From: Shane Cummings
Sent: Monday, June 14, 2021 10:25 AM
To: Donna Johnson; Brad Sutton
Subject: FW: Good Hope Hospital - Revisions

From: Jackson Maples <Jackson@lkcengineering.com>
Sent: Monday, June 14, 2021 9:44 AM
To: Shane Cummings <scummings@harnett.org>; Steve Ward <sward@harnett.org>
Cc: Tim Carpenter <tim@lkcengineering.com>
Subject: Good Hope Hospital - Revisions

SANITARY SEWER PROFILE  
 LINE SS-1

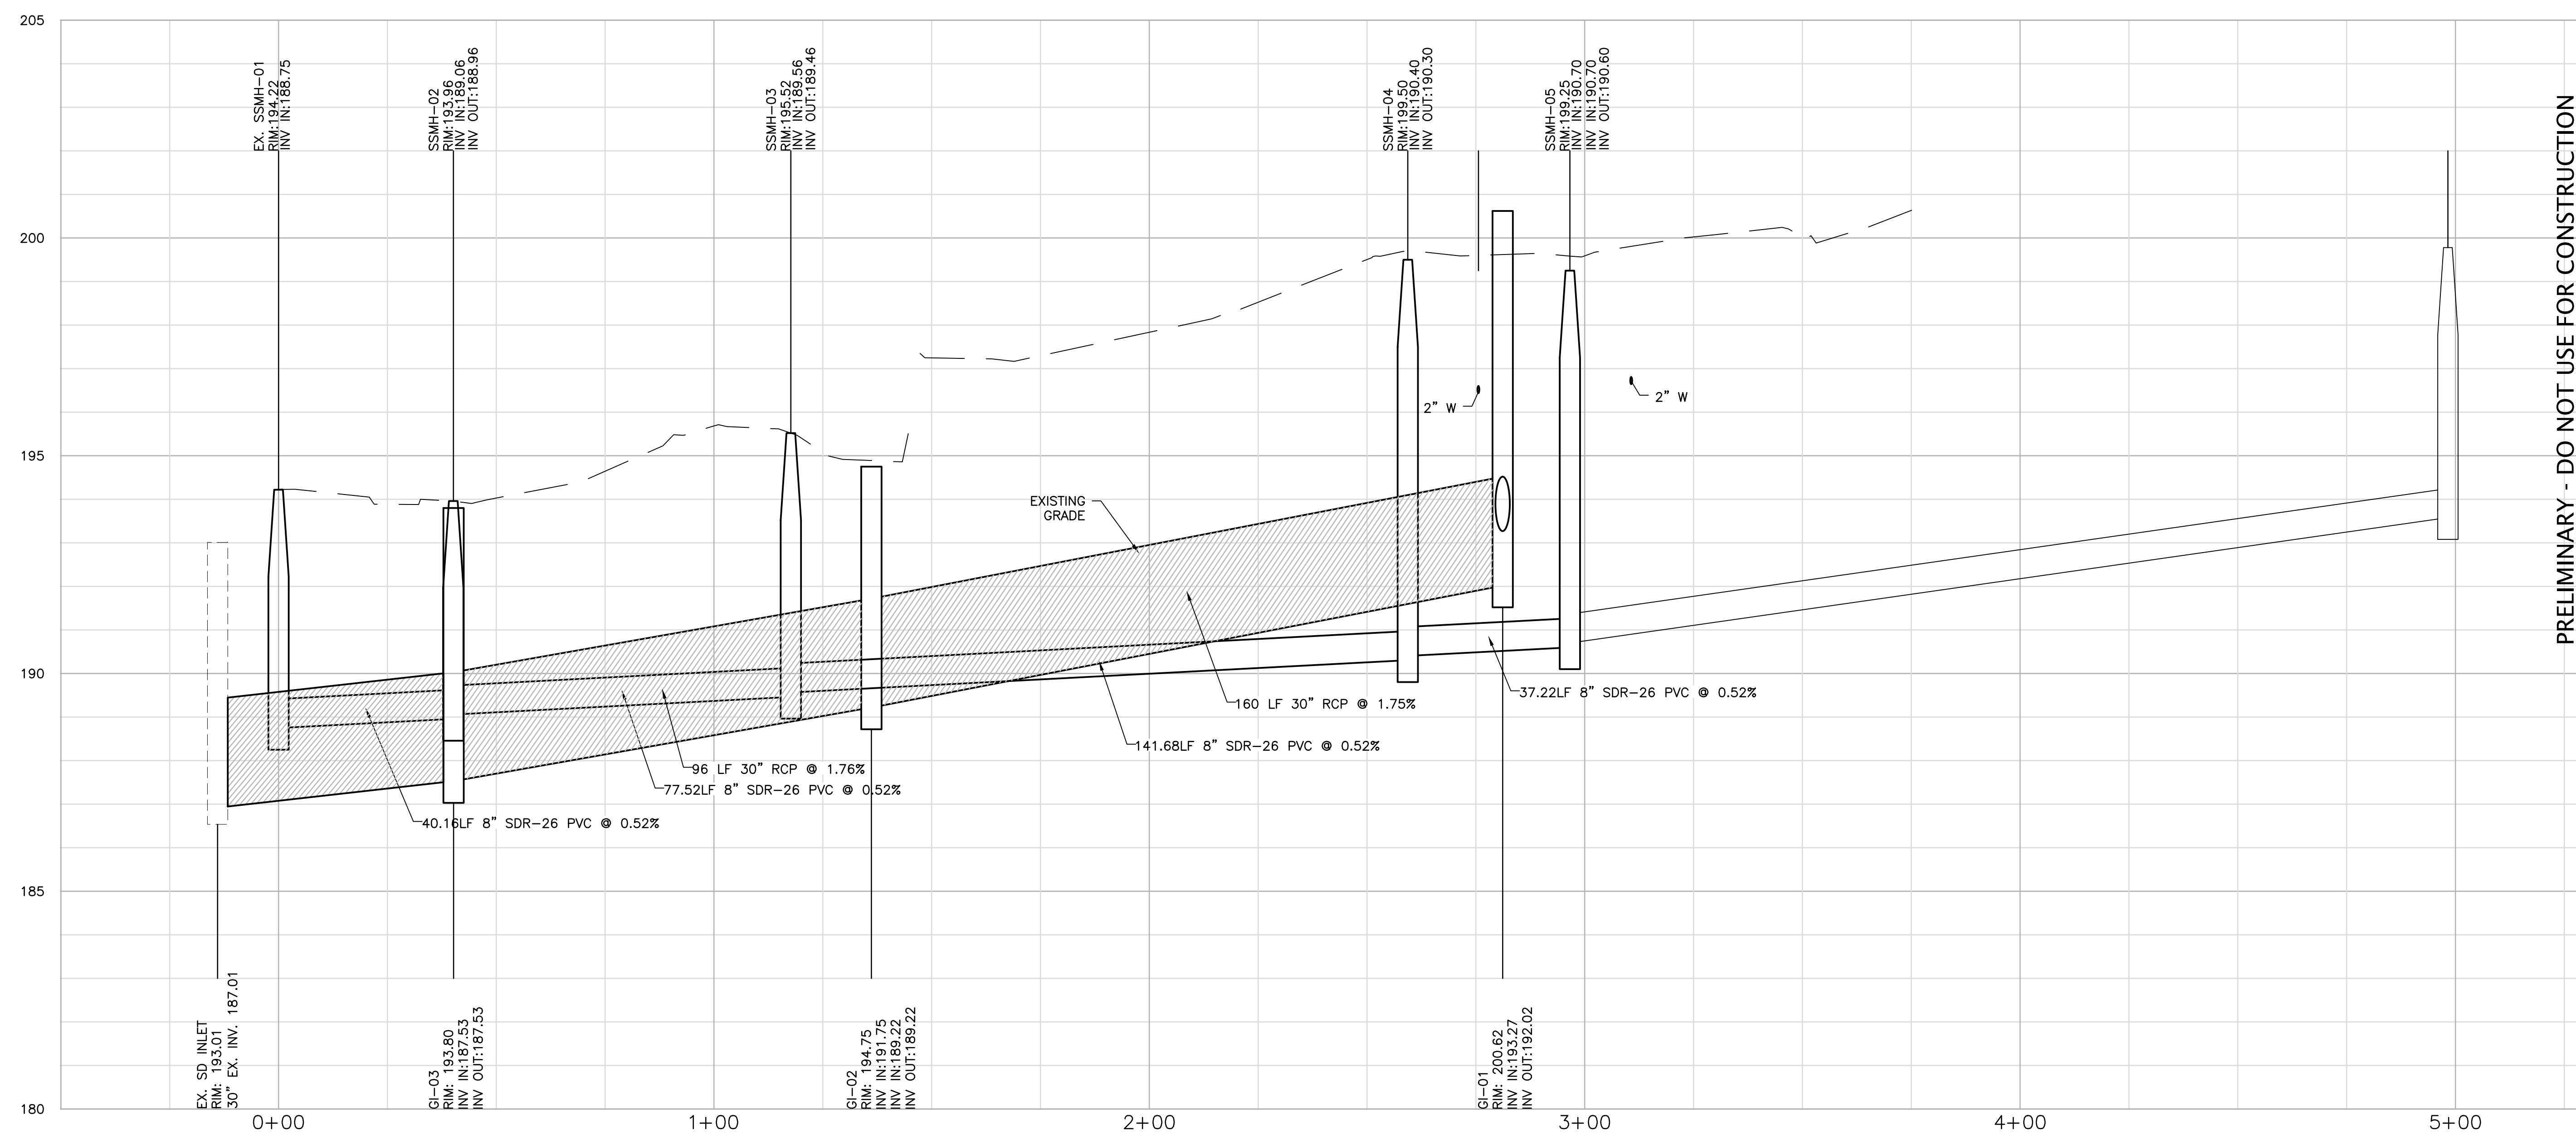
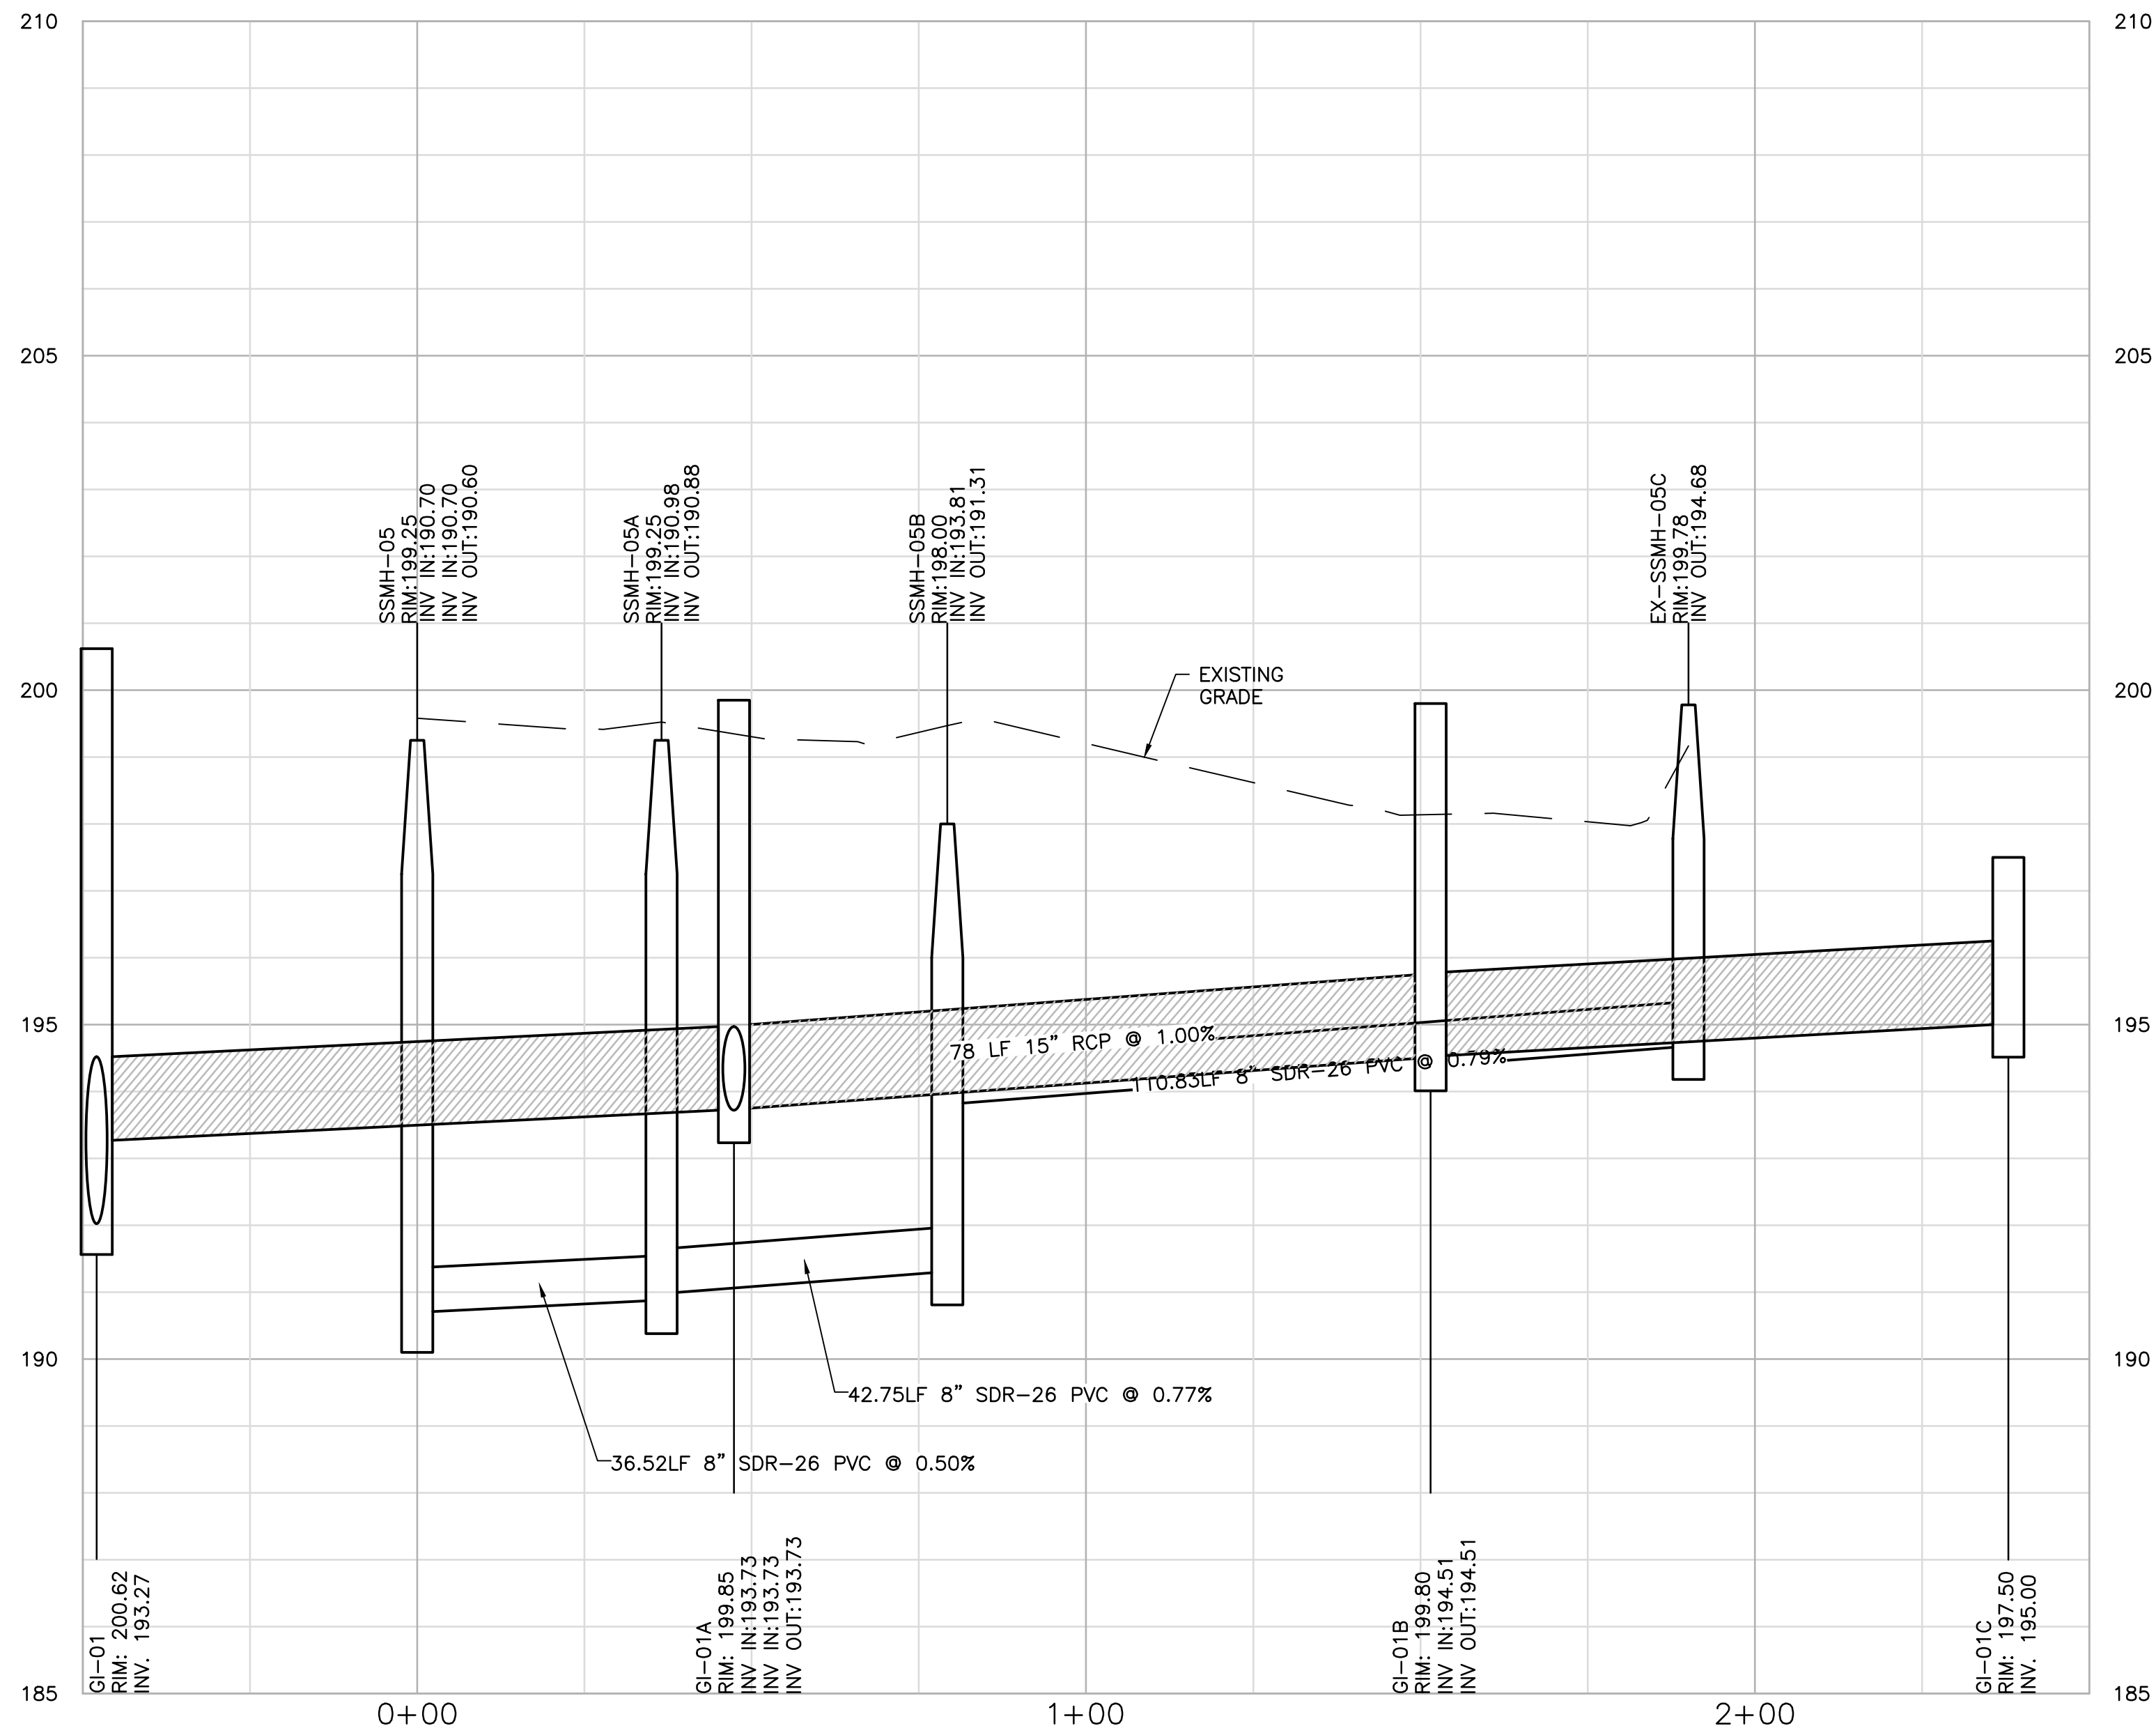
- Revisions including the sewer main relocations, as I understand it, will not be part of this project. Please removed there from the civil site plans.
 - The sewer main relocation has been removed.
- Design criteria must be met for the storm and sewer crossing at ~STA 2+60 of the gravity sewer. Separations currently shown do not meet 15A NCAC 02T .0305 requirements(24-inches). Provide alternatives as required by 15A NCAC 02T .0305 as applicable on the profile sheet.
 - The storm pipe that crossed the sewer at station ~STA 2+60 has been shifted to avoid the cross altogether due to separation requirements.
